LAND TECHNOLOGIES, INC.

Response to Comments

Project Name: Lakewood PRD
 Project File Number: PA22-007
 Review Completion: March 15, 2022

SHEET
P1 of P6
24x36
PA22-007

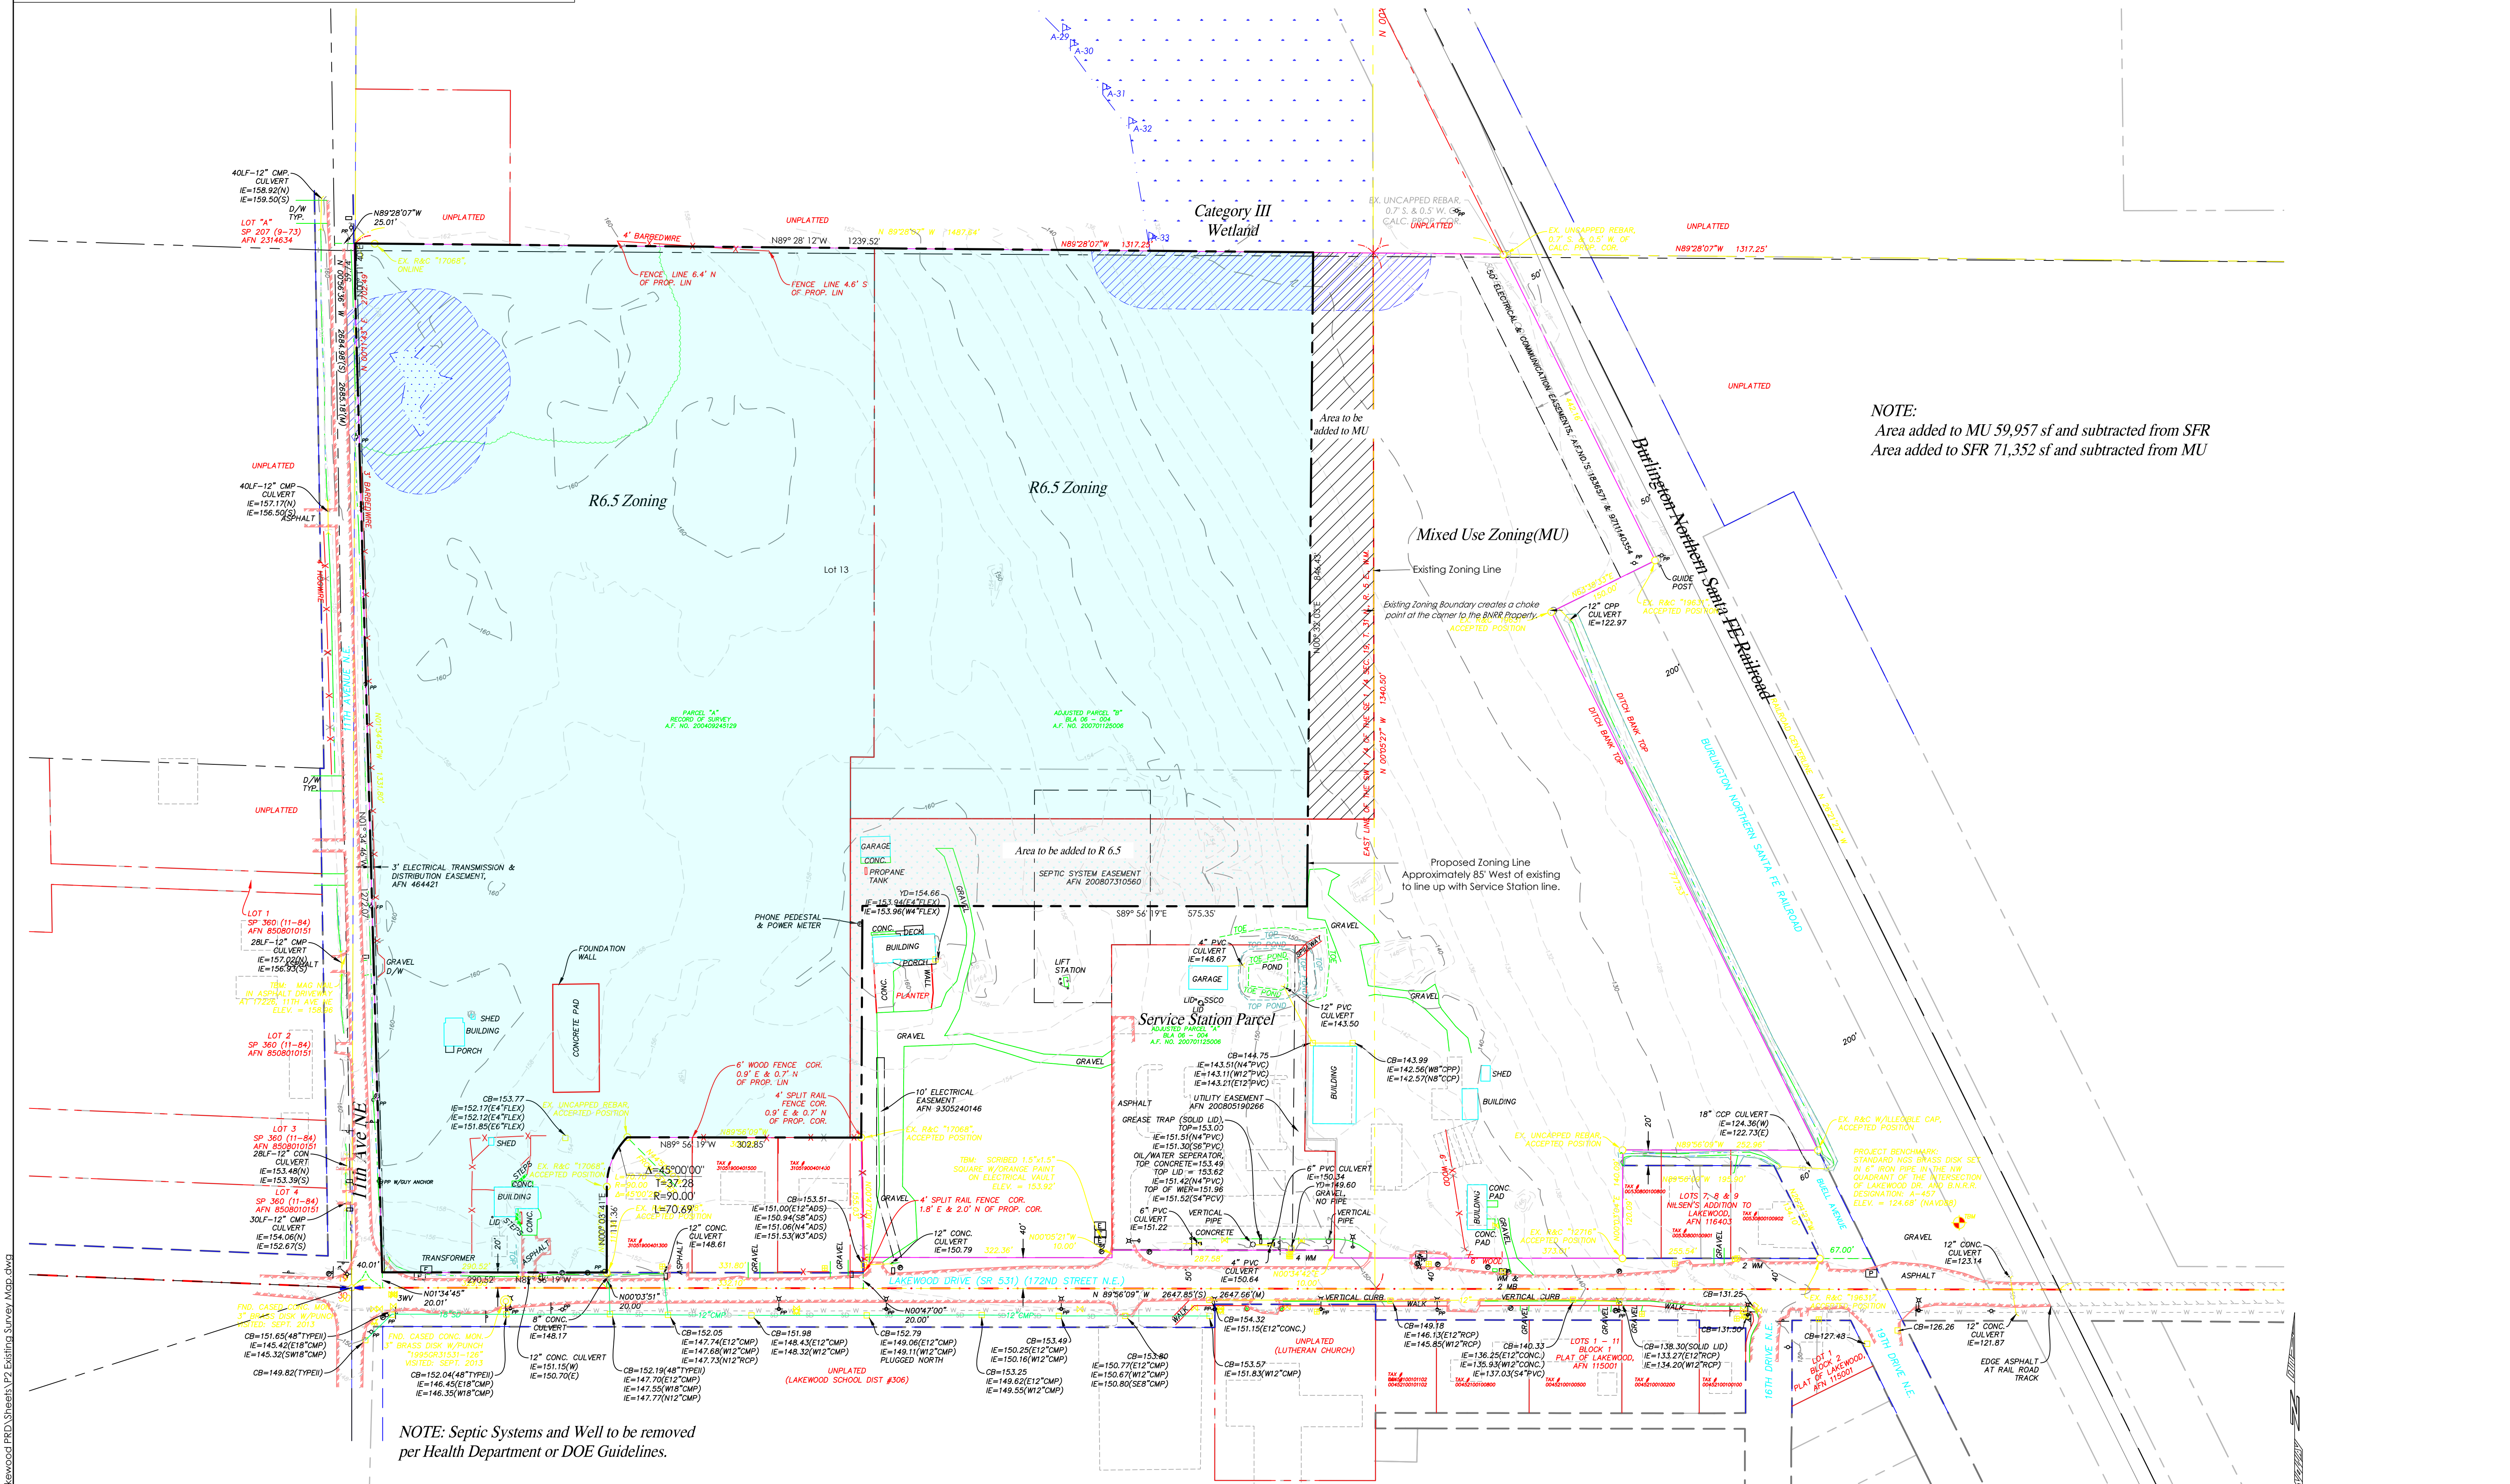
<p>5. Tract 590 appears to be for future right-of-way (ROW) dedication, though it is not included in the Tract Designation Table on sheet P3 of P5. ROW dedication and necessary improvements are required at time of plat development and cannot be set aside for future (see comments from Jesse Hannahs and Shane Whitney).</p>	<p>Tract 590 is just that; this tract was established just to allow for ROW Dedication when it was finally determined what would be required</p> <p>This ROW along this segment is now shown as dedicated and frontage improvements are shown. A detail is provided with the roundabout to confirm the ROW dedicated is adequate should a Roundabout get built in the future.</p>
<p>6. Pursuant to MMC 22G.090.050(1), all contiguous parcel of land, regardless of date of acquisition or location in different lots, tracts, parcels, tax lots or separate government lots, that are to be subdivided shall constitute a single subdivision. The following tax parcels will need to be included with this application: 31051900400900, 31051900401100, and 31051900401000.</p>	<p>MMC 22G.090.050(1) does clarify with intervening phases removed <i>"All contiguous parcels of land, ..., <u>that are to be subdivided</u>...shall constitute a single subdivision..."</i></p> <p>Note the words of the code that state it applies to parcels <i>"that are to be subdivided"</i> and not to <i>whole parcels with areas not being subdivided</i>.</p> <p>The BLA will help resolve this issue. On these parcels, we have two distinct zones. Whoever develops the MU zone will complete these frontage improvements—which is as it should be.</p>

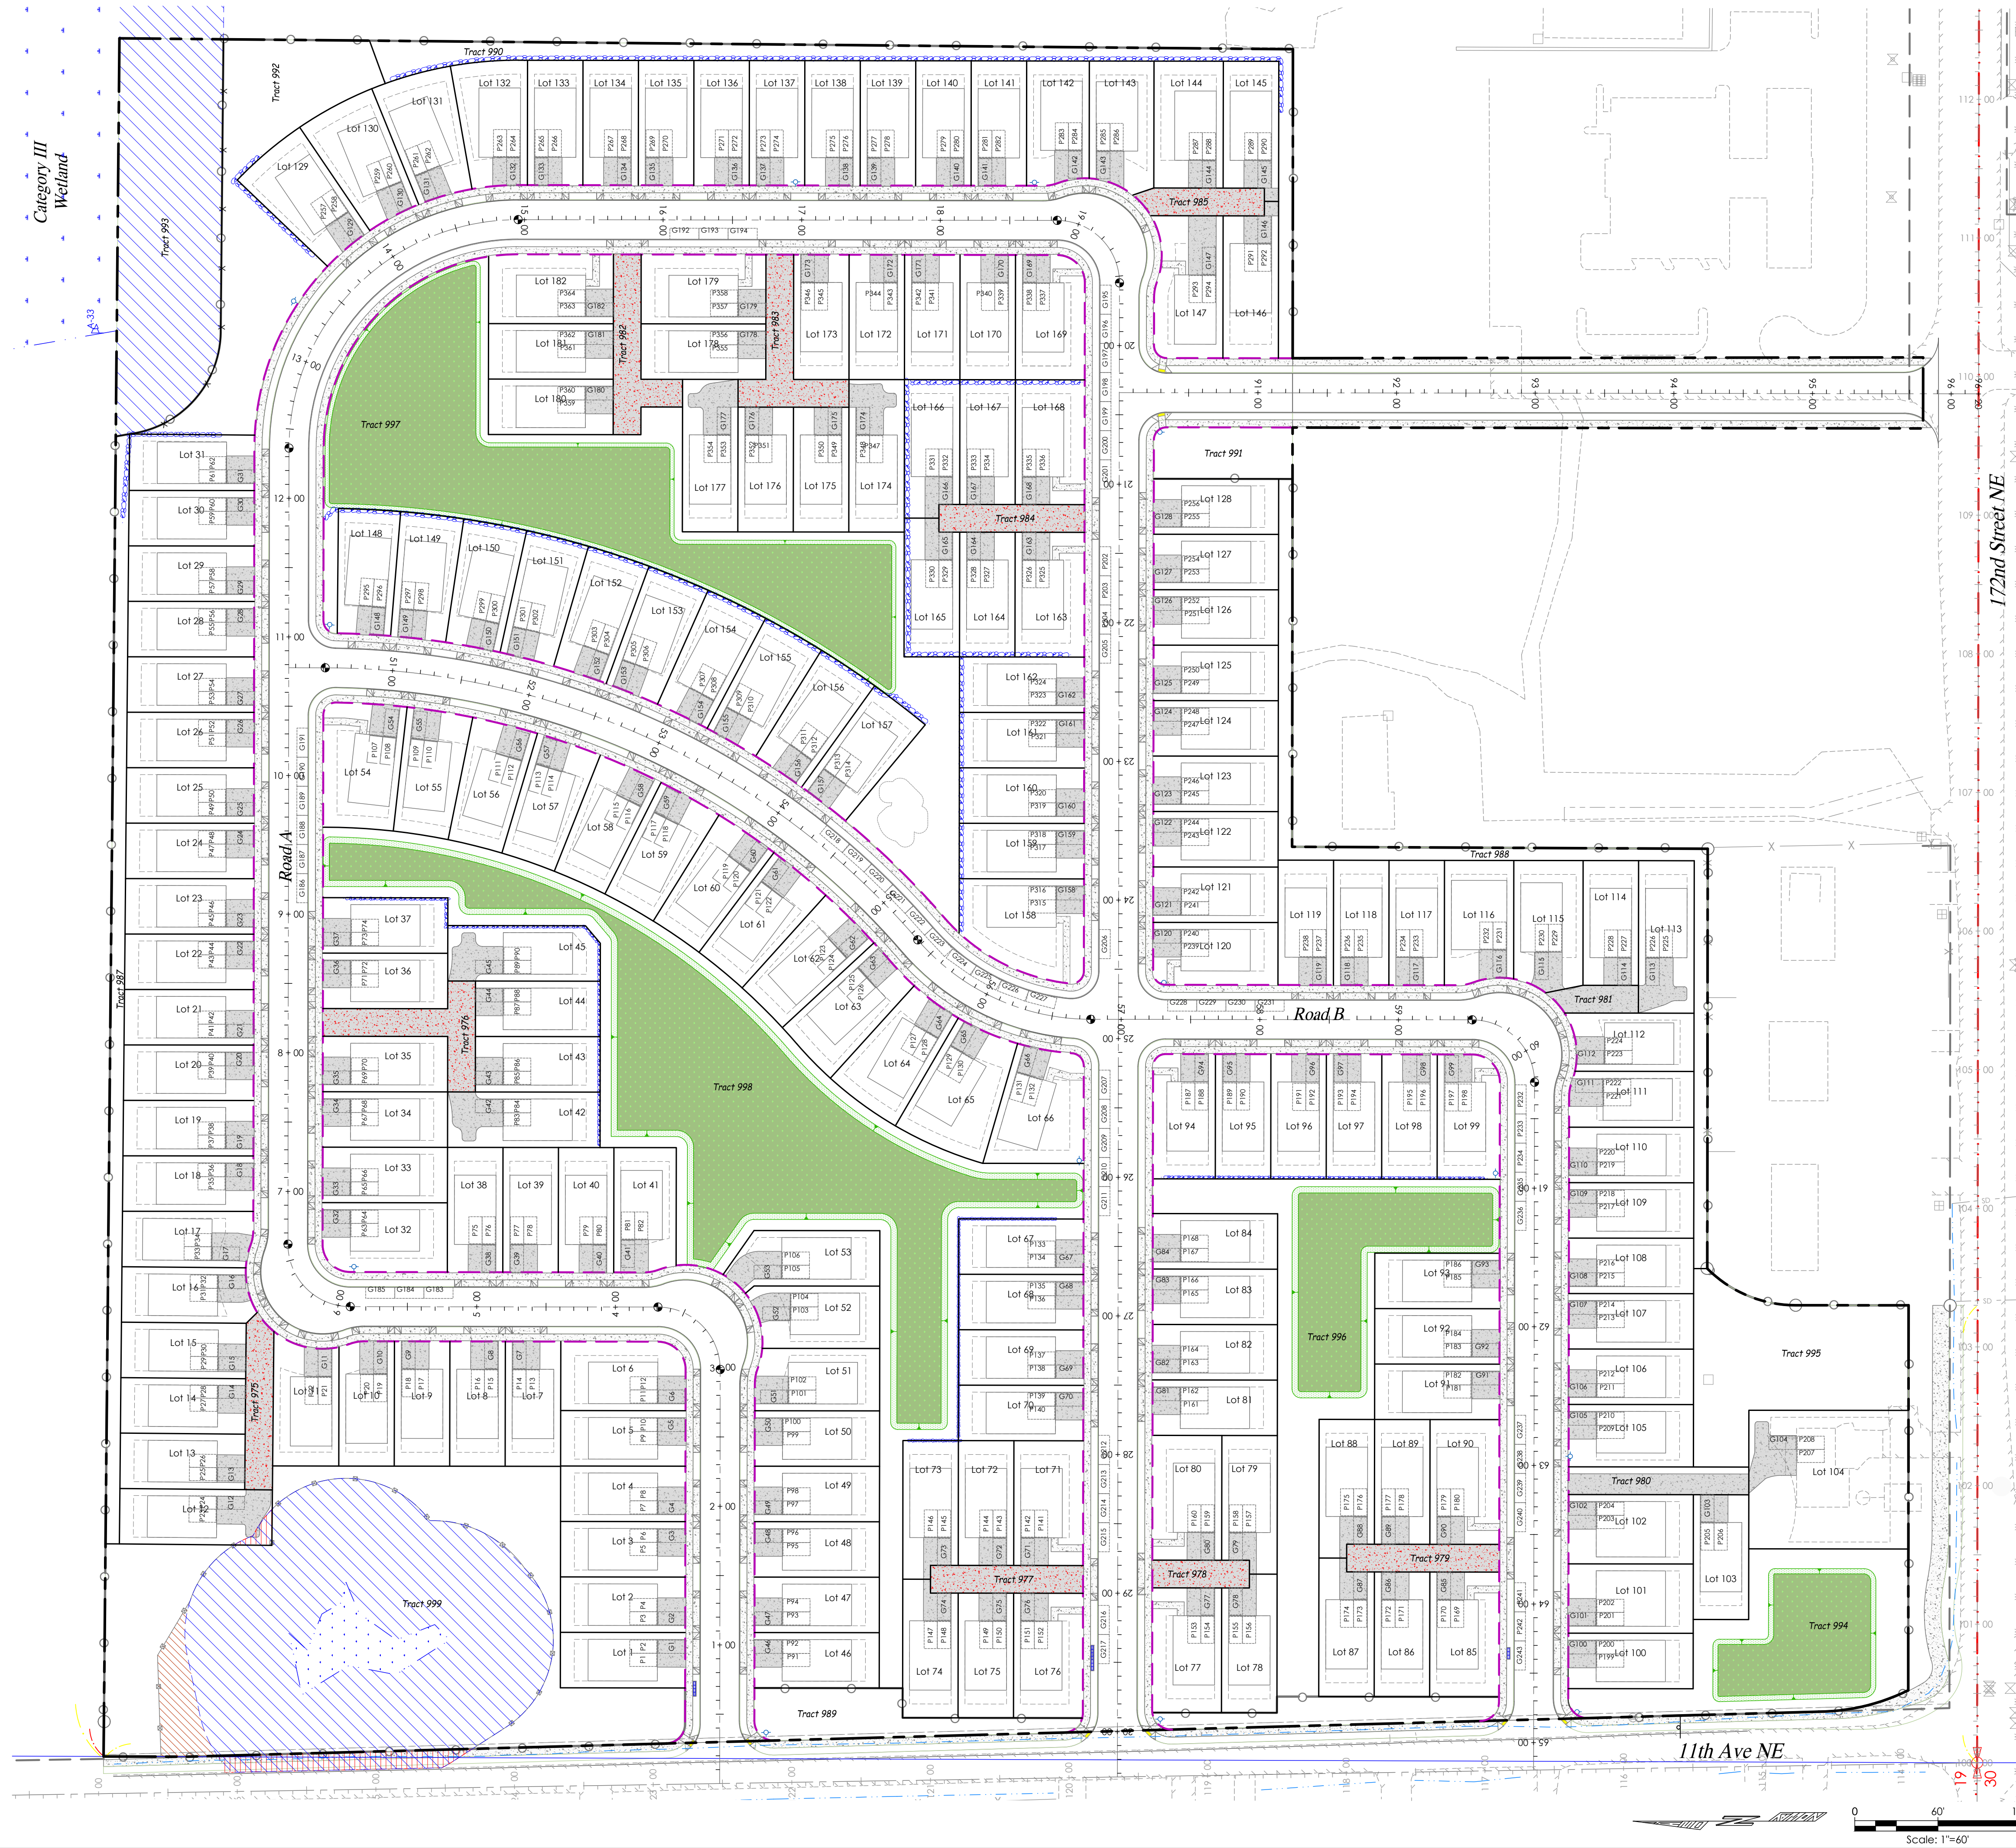
<p>8. The critical areas buffer/Native Growth Protection Area (NGPA) portion of the wetland and buffers should be labeled as an NGPA on the site plan.</p>	<p>The label “NGPA” has been added on planning plans.</p>
<p>9. Pursuant to MMC 22G.080.100(4)(e), open space shall include a minimum of one large recreational amenity or two small recreational amenities per one-quarter acre of active recreation space. Small recreational amenities include commercial-grade benches, picnic tables, small play equipment, and similar amenities. Large recreational amenities include commercial-grade half sport courts, large play equipment, gazebos, and similar amenities. Please provide the total number of large and small amenities to be provided.</p>	<p>Active Open Space Required—1.24 acres Equals 5 ¼-acres</p> <p>Requires:5 large recreational Amenities and 10 small recreational amenities.</p> <p>Providing:</p> <ol style="list-style-type: none"> 1. Large reinforced grass turf areas for multi-sport type activities. 2. Grass reinforced Soccer Field 3. Grass reinforced Volley Ball Court 4. Grass reinforced Badminton Court 5. 2 Bocce Ball/Lawn Bowling Lanes. 6. Horseshoe Pit. 7. Large Play Equipment 8. Eleven Commercial Grade Benches 9. One Picnic Table
